**20.2 MAJOR PROJECT MP09\_0066 MODIFICATION 3 – ALBERT AVENUE/THOMAS STREET, CHATSWOOD (CAR PARK SITE) SUBMISSION TO THE DEPARTMENT OF PLANNING**

**SUBMISSION BY WILLOUGHBY CITY COUNCIL ON PROPOSED MODIFICATION 3 OF THE APPROVAL MP09\_0066 FOR THE SITE KNOWN AS THE THOMAS STREET CAR PARK SITE IN CHATSWOOD**

SP 11

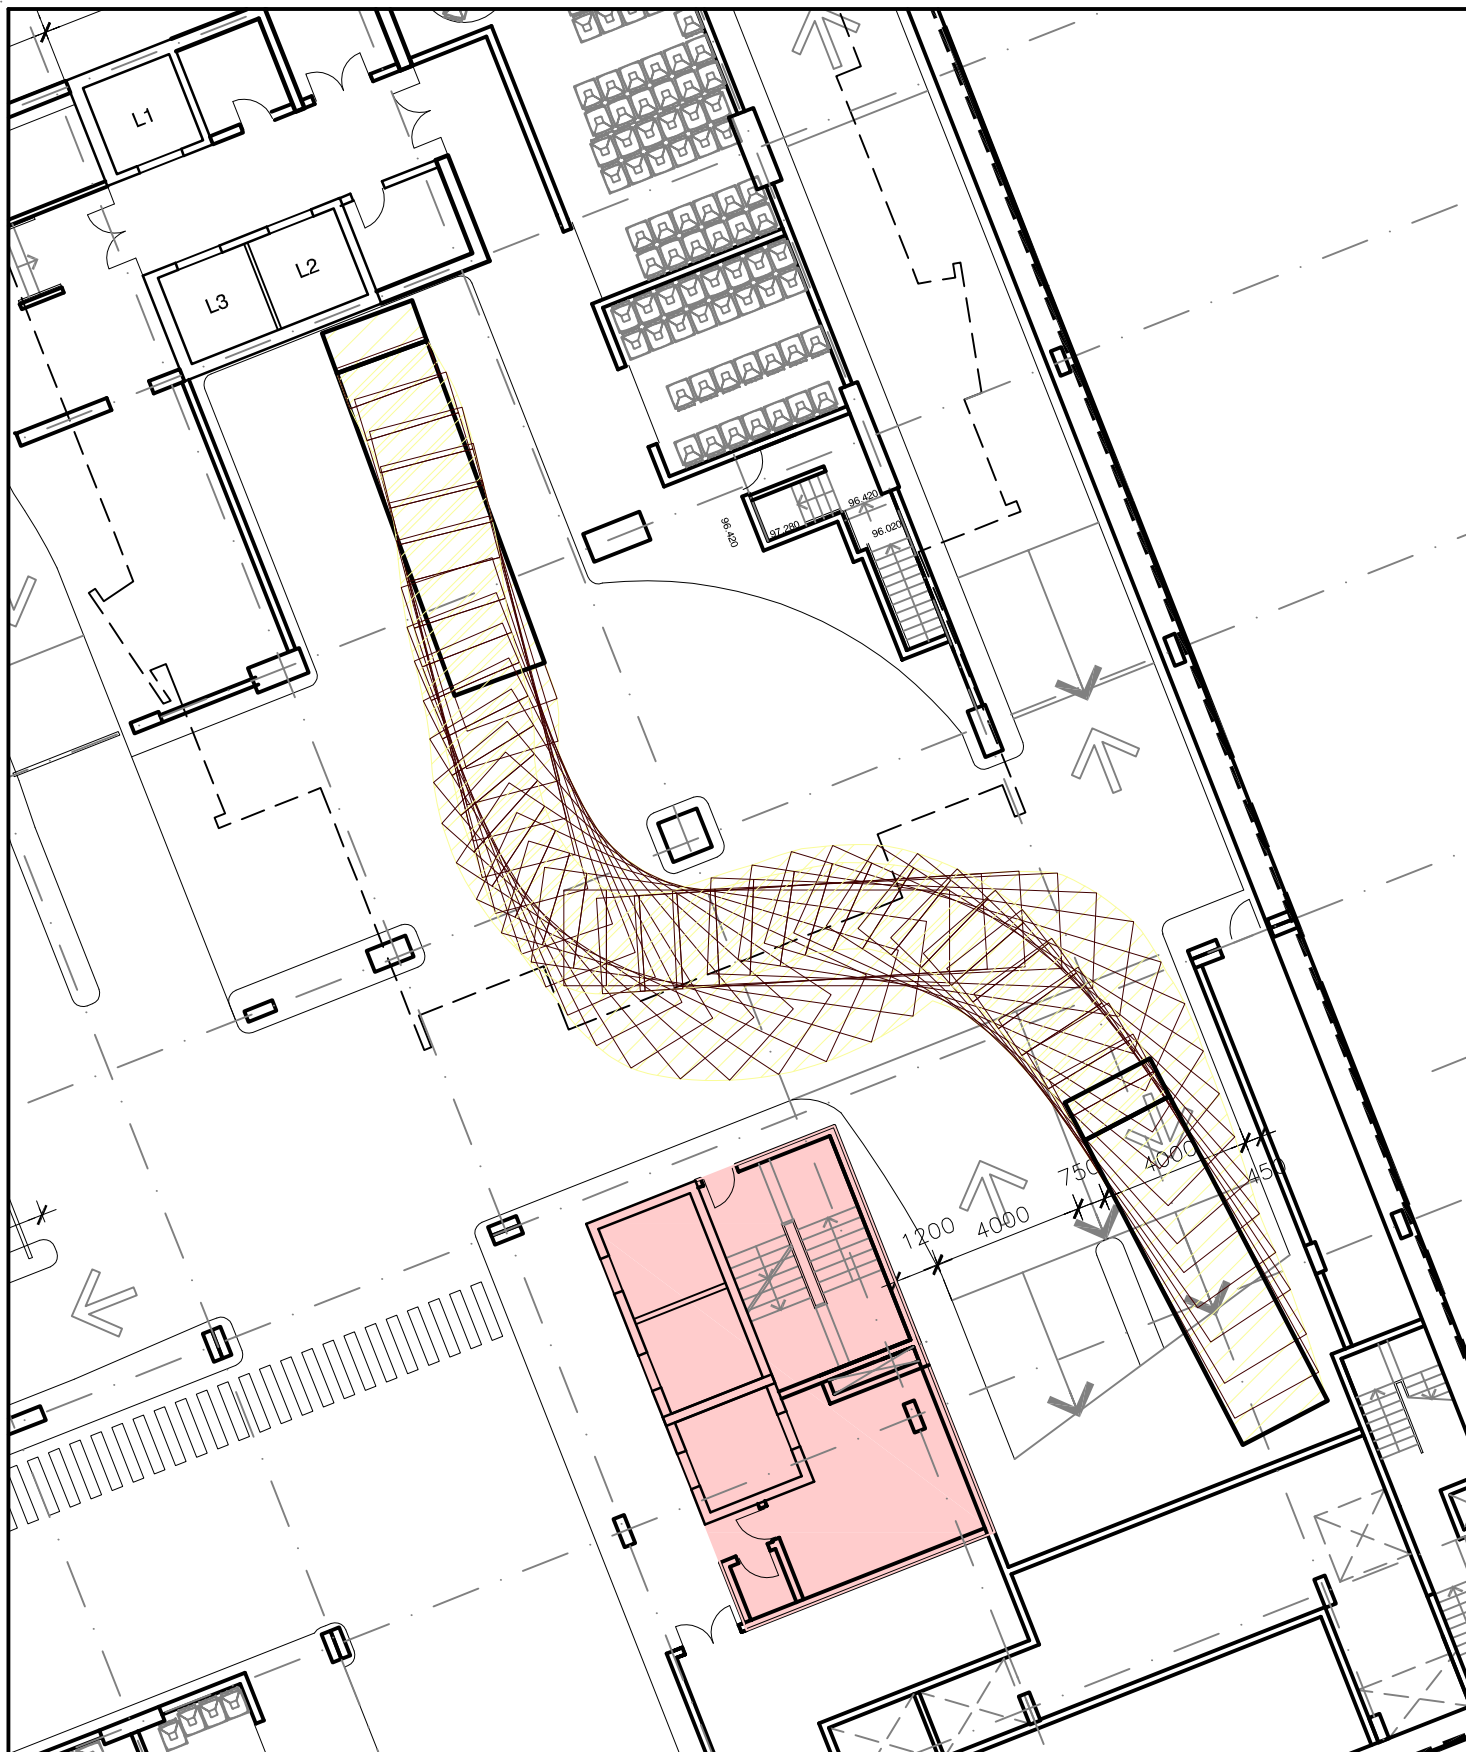
- f) Council in the original application has previously raised concern regarding the design of the loading docks and manoeuvring of trucks. The amended design provides separated area from the circulating aisles for manoeuvring that is an improvement from the original design. However, the short term spaces for couriers have been removed and column positions require precision driving by trucks accessing the loading docks. One medium rigid (8.8 metres) and one small rigid truck are the maximum capacity of the two loading docks. When a 10.2m truck is using the loading

dock manoeuvring space precludes the ability for the truck to position itself to allow use by another truck. It is noted that the size of garbage vehicle that is used by Council for residential buildings of the proposed scale is the 10 metre medium rigid trucks.
